Project name	Wykham Park Farm, Banbury		
Design note title	Technical Note - Response to Condition 10 Planning Comments		
Document reference	C04583		
Author	Sean Mitchinson		
Revision	P1		
Date	1 July 2020	Approved	<input type="checkbox"/>

This Technical Note has been produced in response to Oxfordshire County Council comments dated 09<sup>th</sup> June 2020 and should be read in conjunction with the Hydrock Drainage Strategy Report (Ref: WPF-HYD-XX-XX-RP-C0003) and Wardell Armstrong Flood Risk Assessment (Ref: CA10769 dated November 2014)

CLIENT	L&Q ESTATES
PROJECT	WYKHAM PARK FARM, BANBURY
TITLE	PROPOSED SWALES TYPICAL SECTIONS
HYDROCK PROJECT NO.	C-04841-C
SCALE @ A1	AS SHOWN
PURPOSE OF ISSUE	SUITABLE FOR INFORMATION
STATUS	S2
DRAWING NO. (PROJECT CODE-ORIGINATOR-ZONE-LEVEL-TYPE-ROLE-NUMBER)	WPF-HYD-XX-XX-DR-C-2101
REVISION	P4

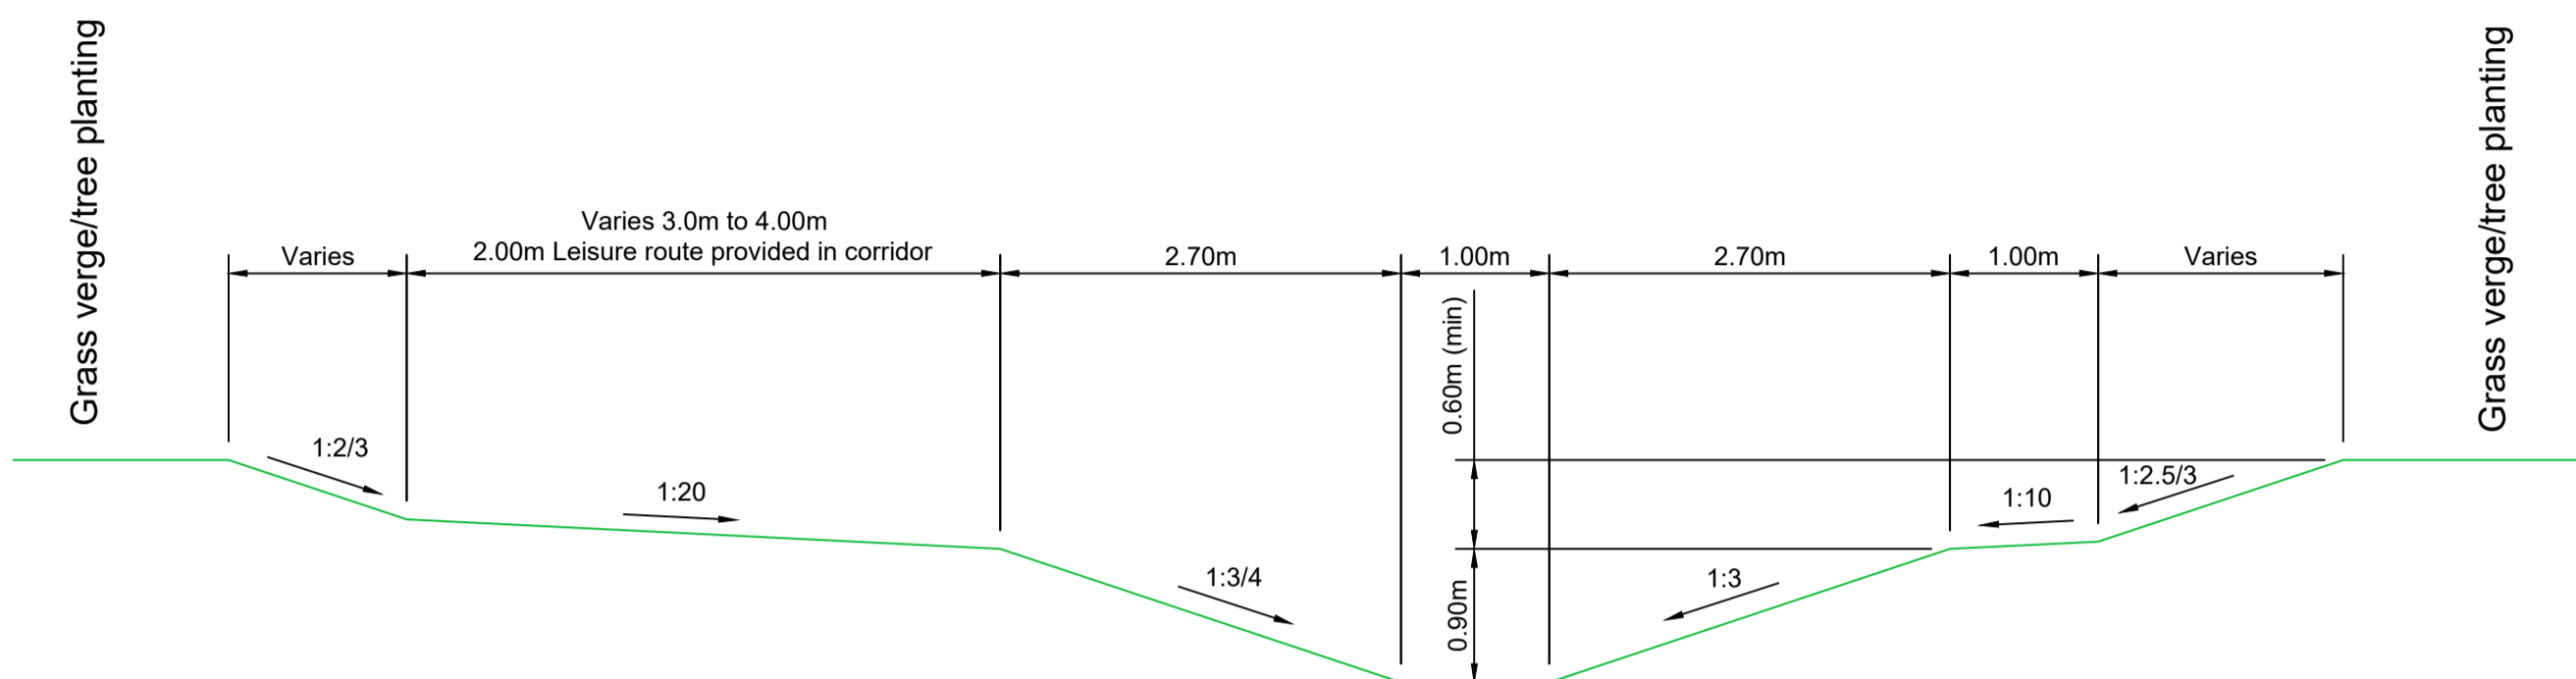
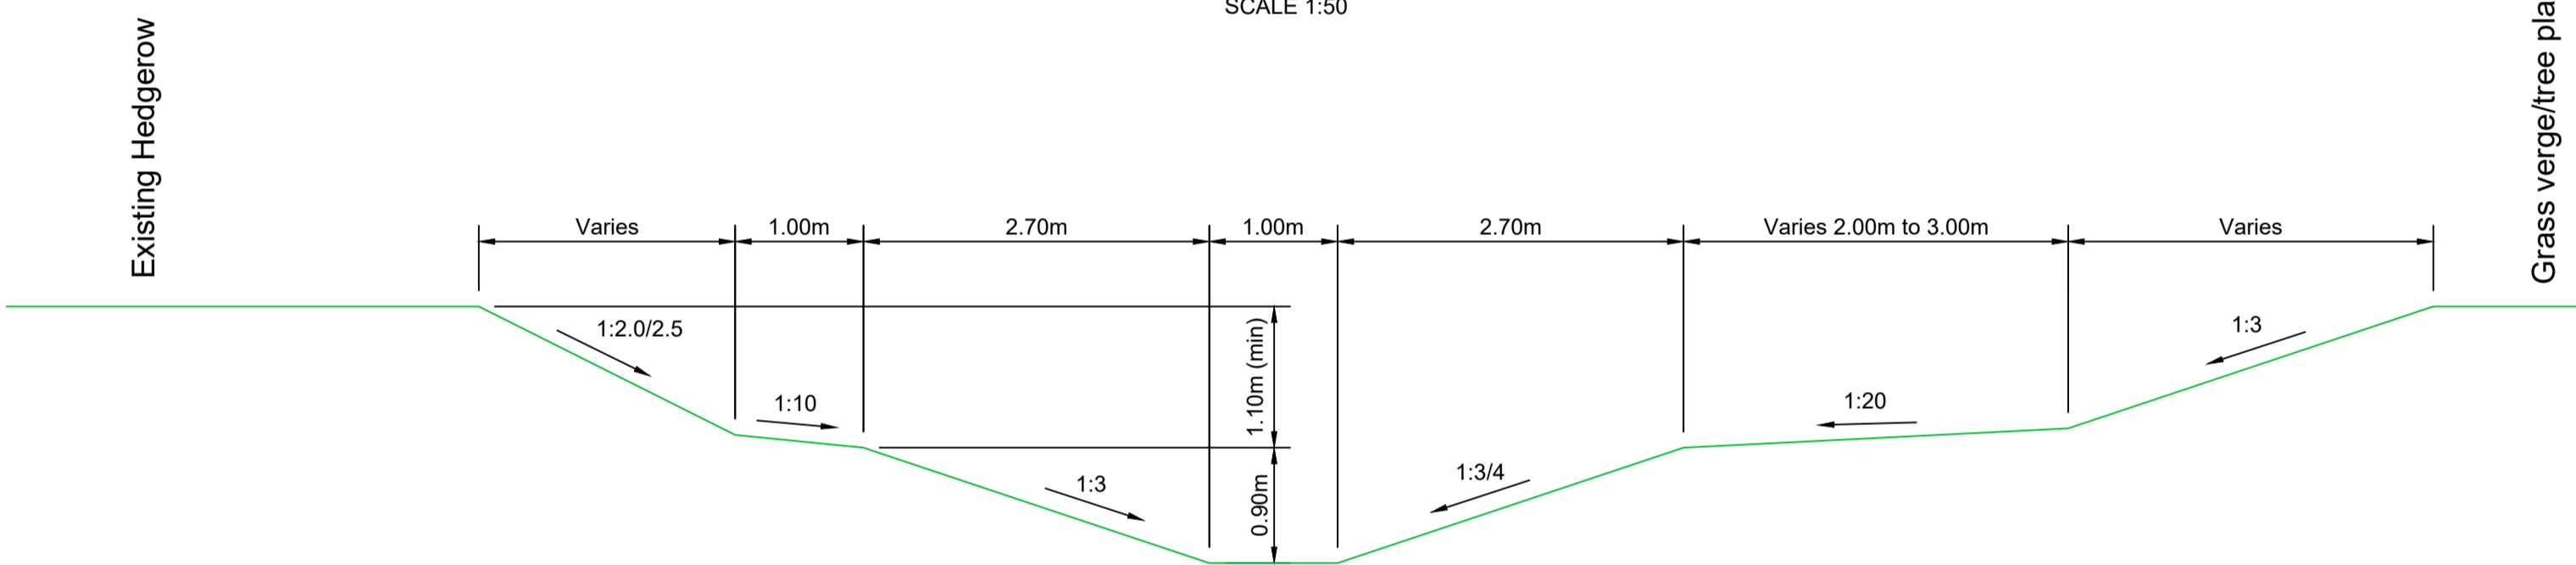
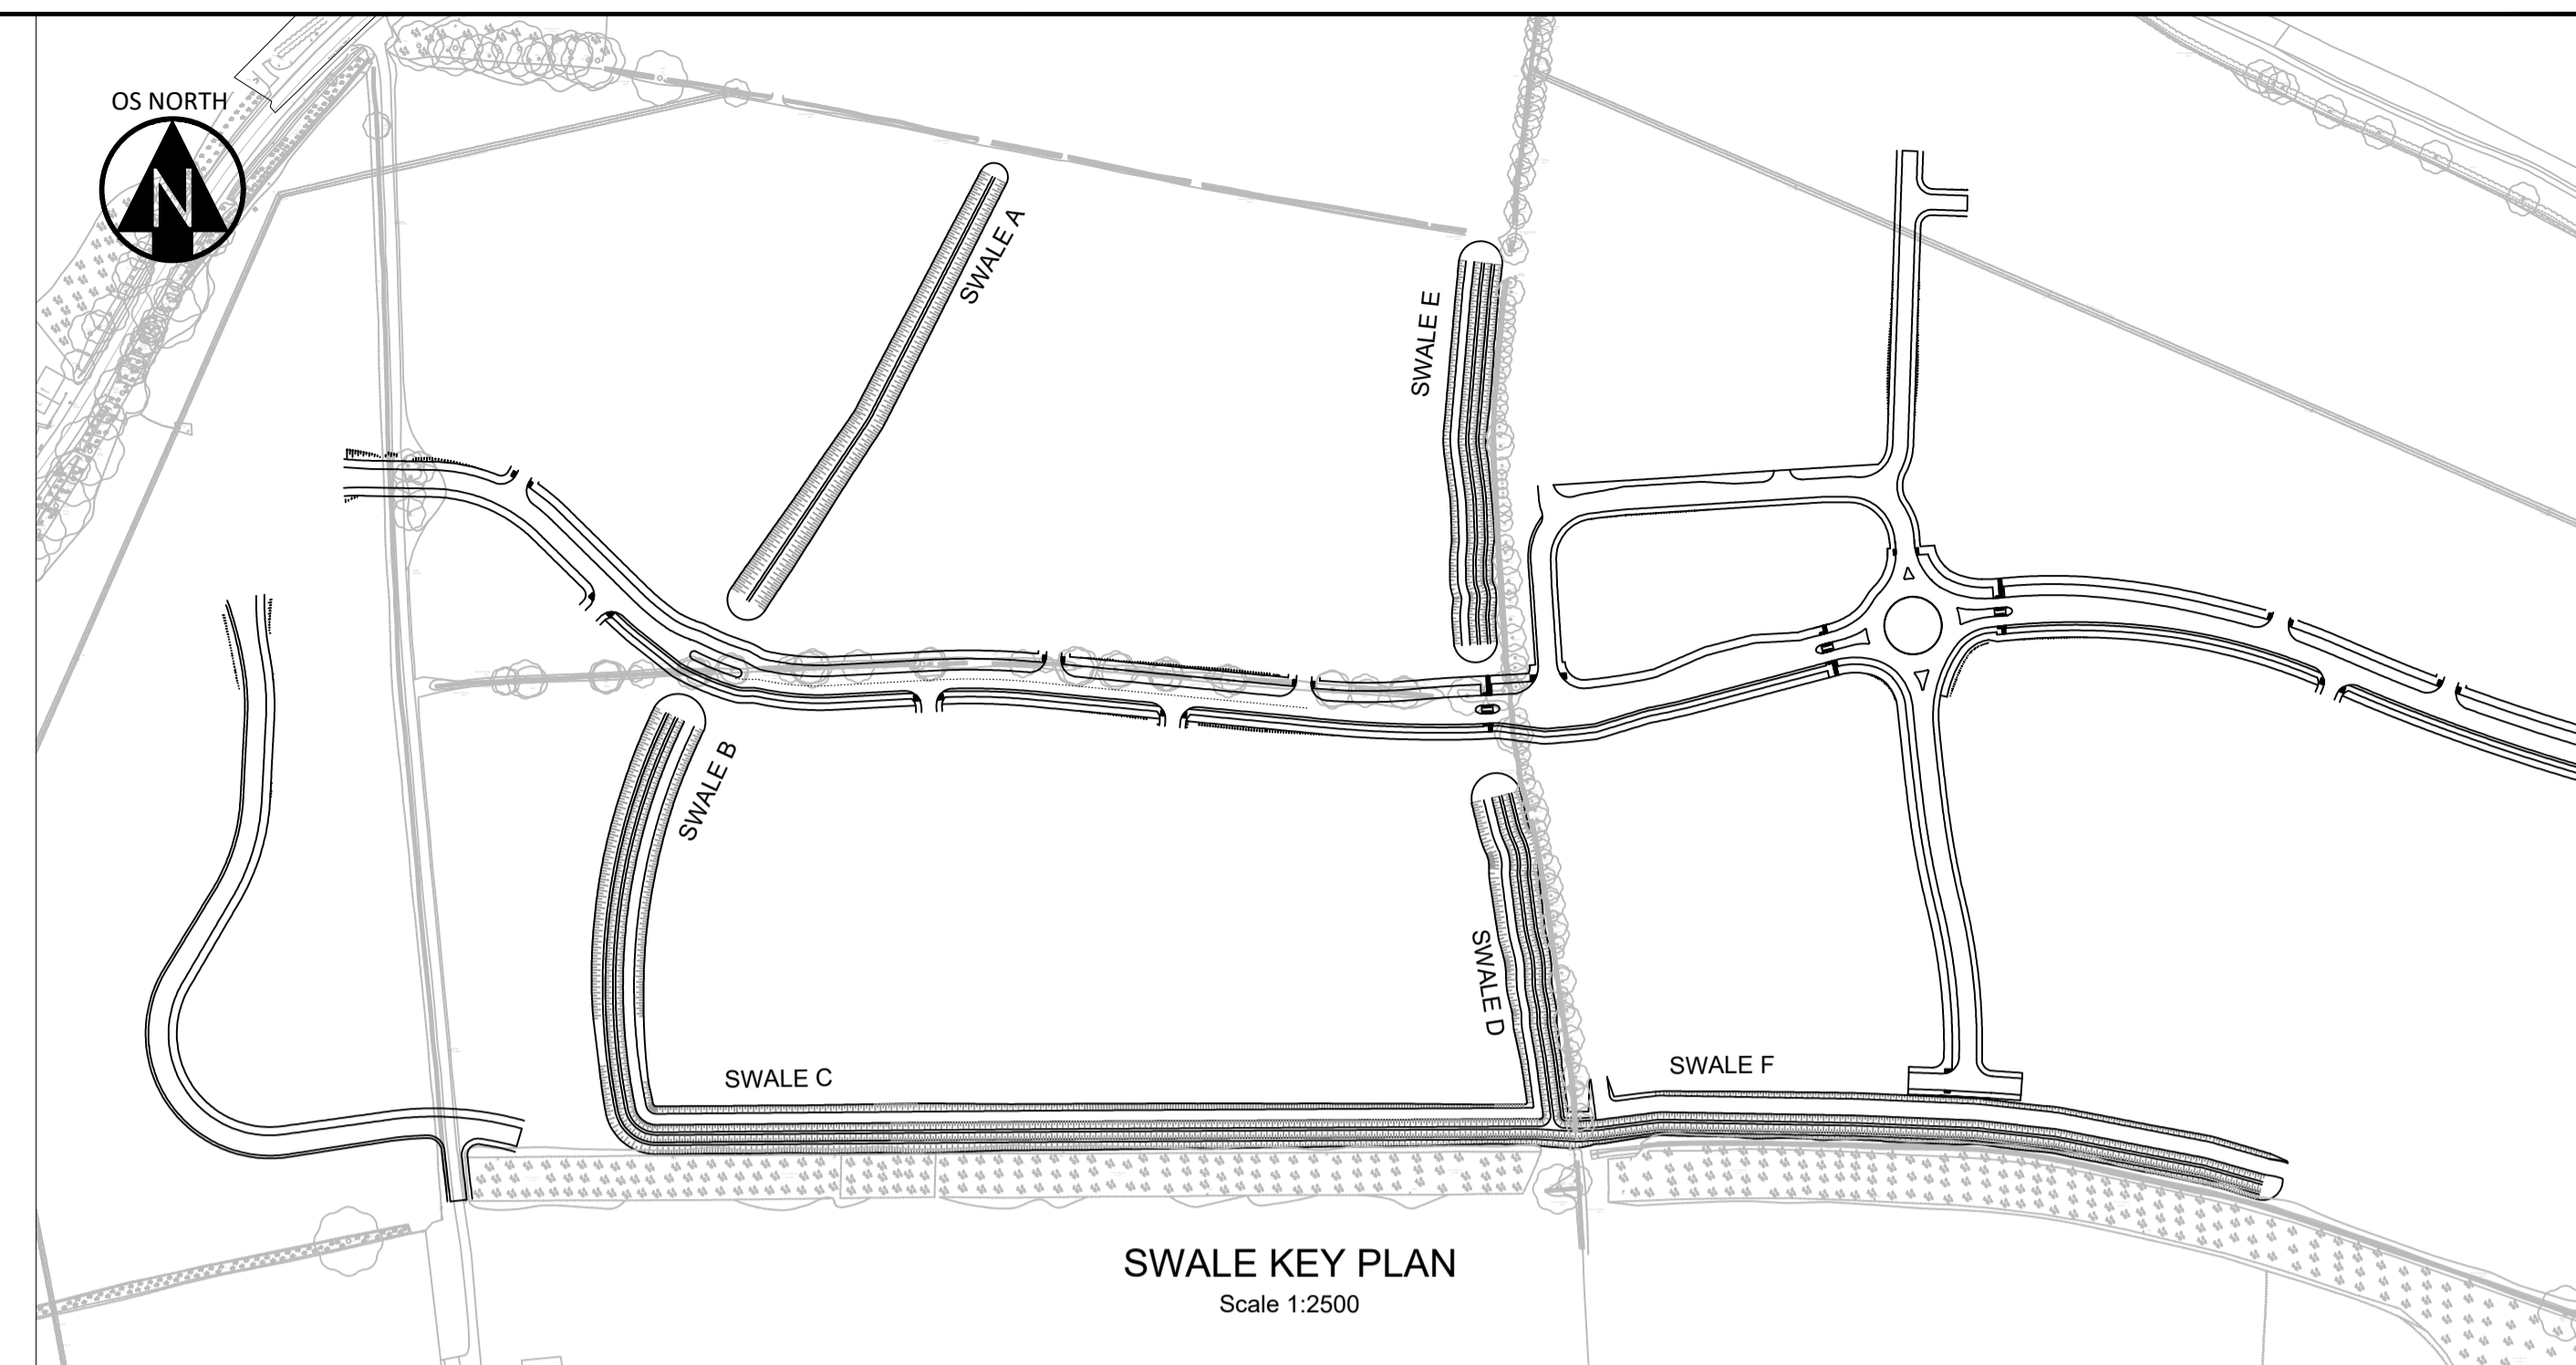
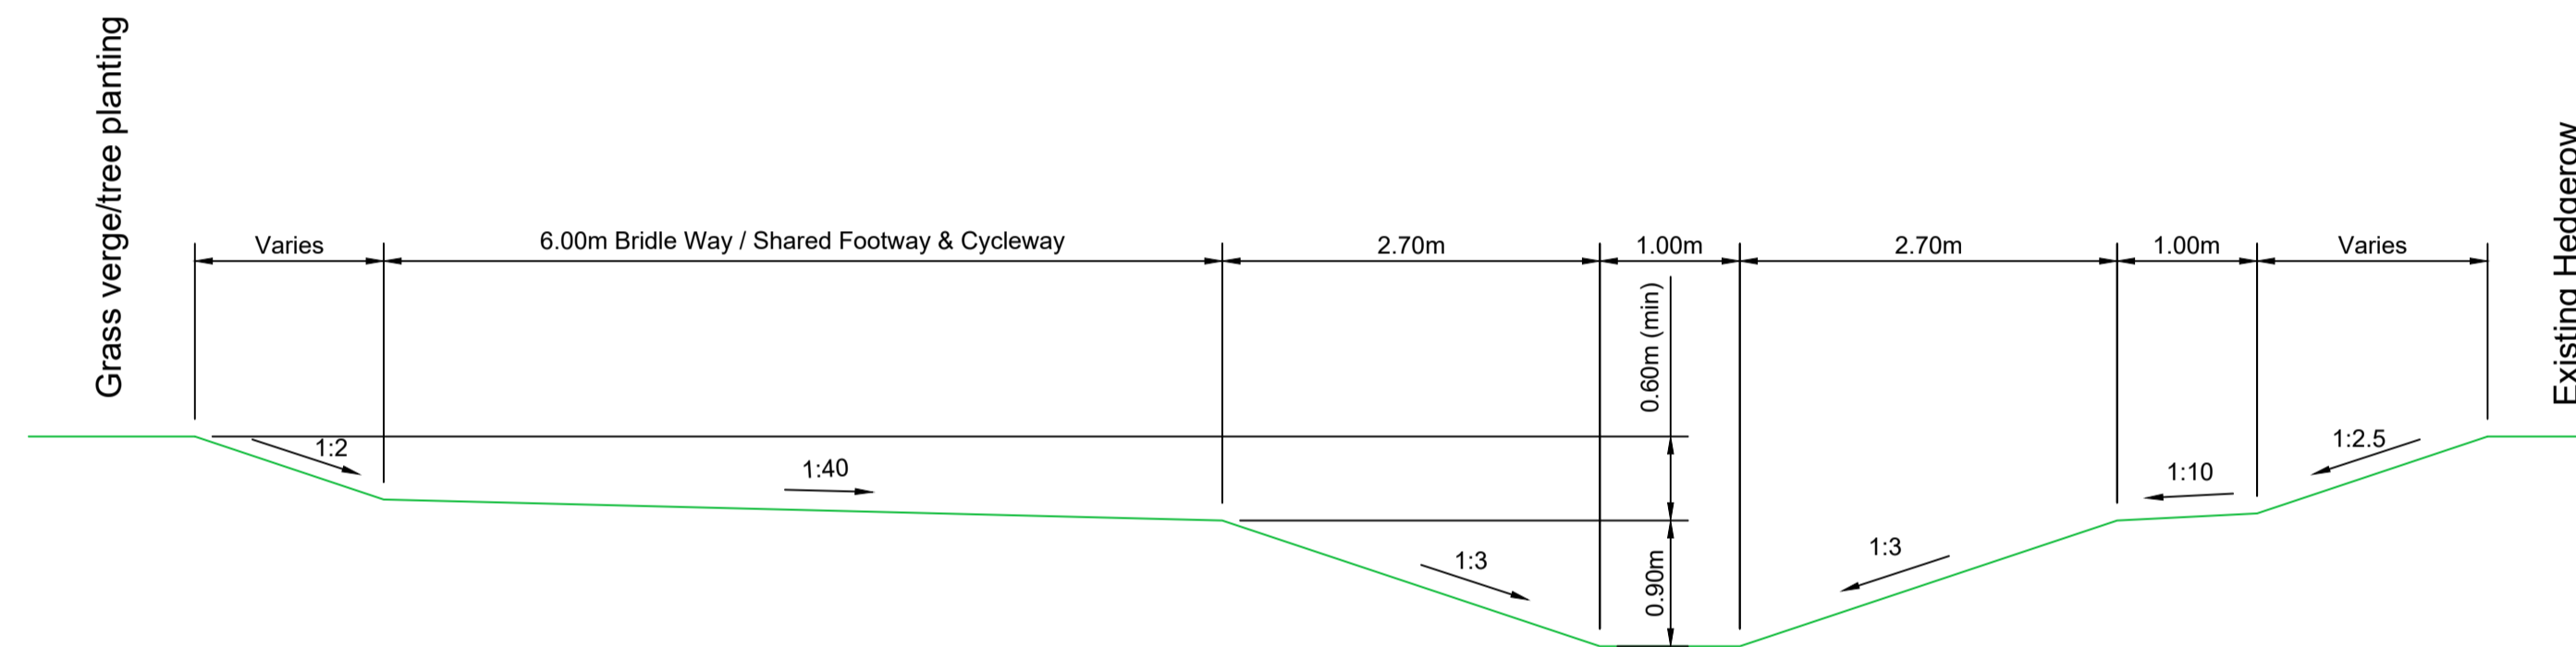
- 1.3.3 Cross sectional plans of the swale profiles and attenuation basins are shown on drawing WPF-HYD-XX-XX-DR-C-2101.
- 1.3.4 A draft Management and Maintenance Plan for the various SuDS elements are included within the Drainage Strategy Report in Table 8. A standalone document can be produced once the responsibility for each SuDS element has been determined.

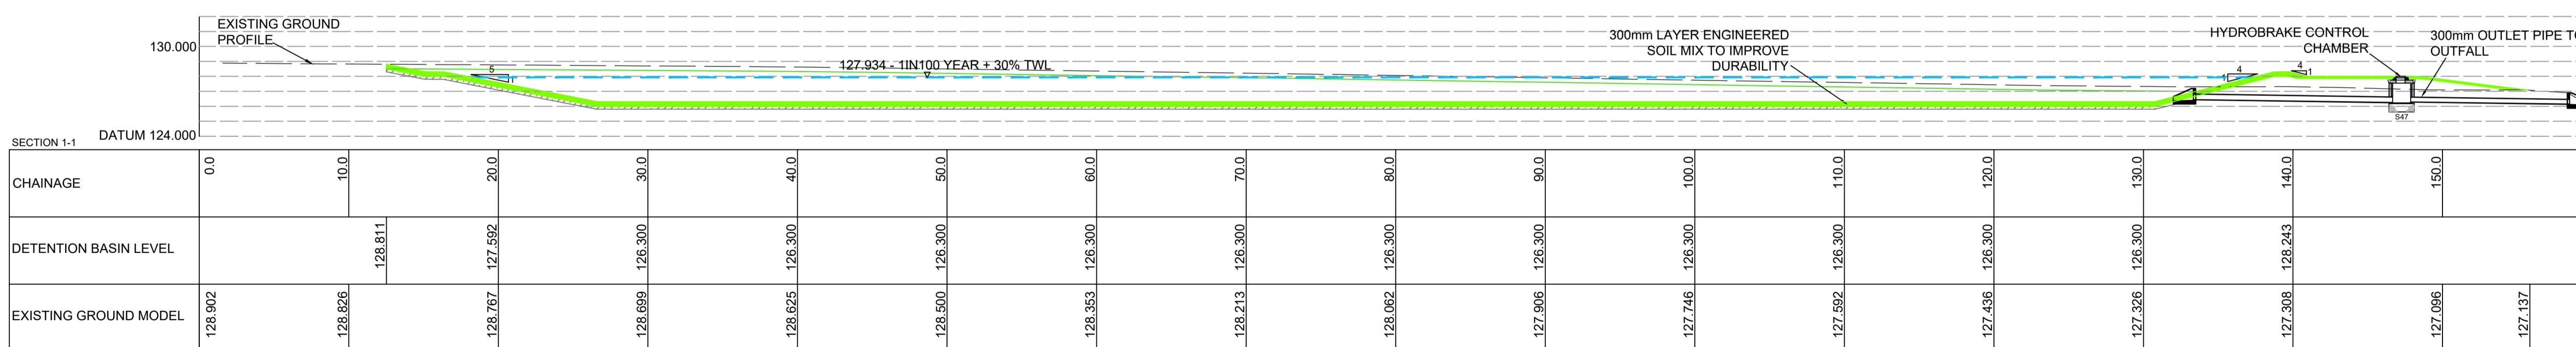
- 1.2.4 Freeboard level for attenuation features added to the Drainage Strategy Report in Table 5. In addition to this the freeboard levels have been added to the attenuation basin cross section plan (ref WPF-HYD-XX-XX-DR-C-2101). Freeboard levels have been kept to a minimum of 300mm.
